DECISION DELEGATED TO HEAD OF PLANNING

Application No: H14-0077-26 **Applicant:** Remway Design

Proposal: Extensions and Alterations - Approved under H14-0931-19. Modification of Condition 2 to allow amendments to previously approved plans

Location: 3 Penway Drive Pinchbeck Spalding

Proposed Block Plan  
1 : 250

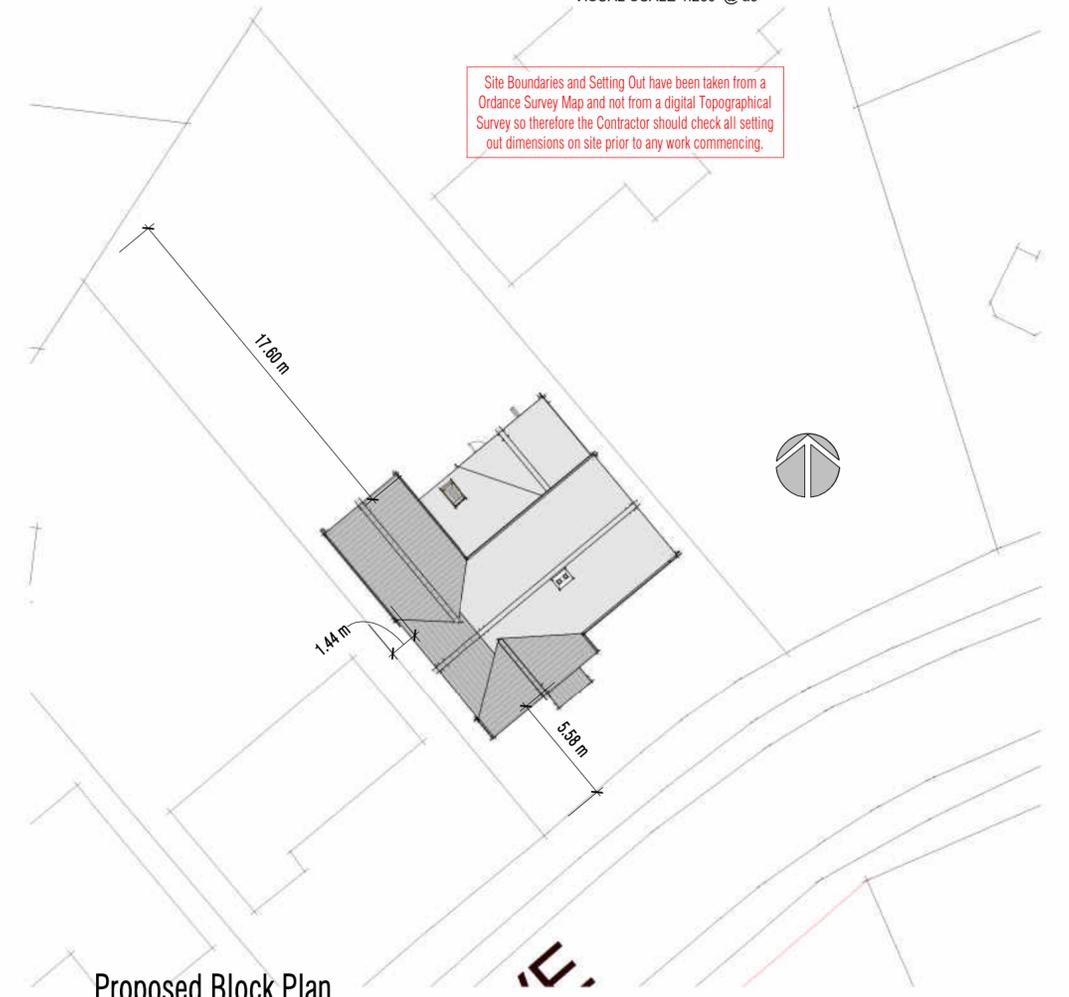
Taken in isolation of the surrounding area, the extension is reasonably well integrated into the host. The lowering of the ridge height in the proposed rear element would help to create visual subservience, making it appear as a subservient addition.

The proposed changes to the rear are substantial, in comparison to the original permission H14-0931-19. That being said, as the change is to the rear, from a visual perspective, the perceived mass would not be overly substantial.

The proposed additional west facing first floor windows connect onto bathrooms. Therefore, whilst these features would ordinarily represent a potential overlooking concern, it would not be unreasonable to request that these windows are obscure glazed, thereby preventing an adverse impact.

That being said, the amendment would have a significant adverse overshadowing effect. The distance to the neighbouring plot is approximately 1.44m, with a distance to the nearest elevation being approximately 3m. At this distance, the proposal would significantly restrict light entering the large rear facing windows of 5 Penway Drive. These windows are north-east facing, and so would be anticipated to receive a good level of light and would not be subject to the usual allowances for windows facing true north conferred under the BRE guidelines. It has not been evidenced by the applicant that the proposal would not cut significantly reduce residential amenity.

As detailed above, the scale and design of the proposal is considered to have a significant and unacceptable impact on the residential amenities of the occupiers of adjacent properties. As such, the proposal is considered contrary to Section 12 of the NPPF and Policies 2 and 3 of the Local Plan in terms of impact upon residential amenity.

However, the significant scale of the change would result in an unacceptable overshadowing impact upon the dwelling to the west. It is considered that the extent of the shadow cast would result in a level of harm contrary to Policies 2 and 3 of the SELLP and Section 12 of the NPPF.
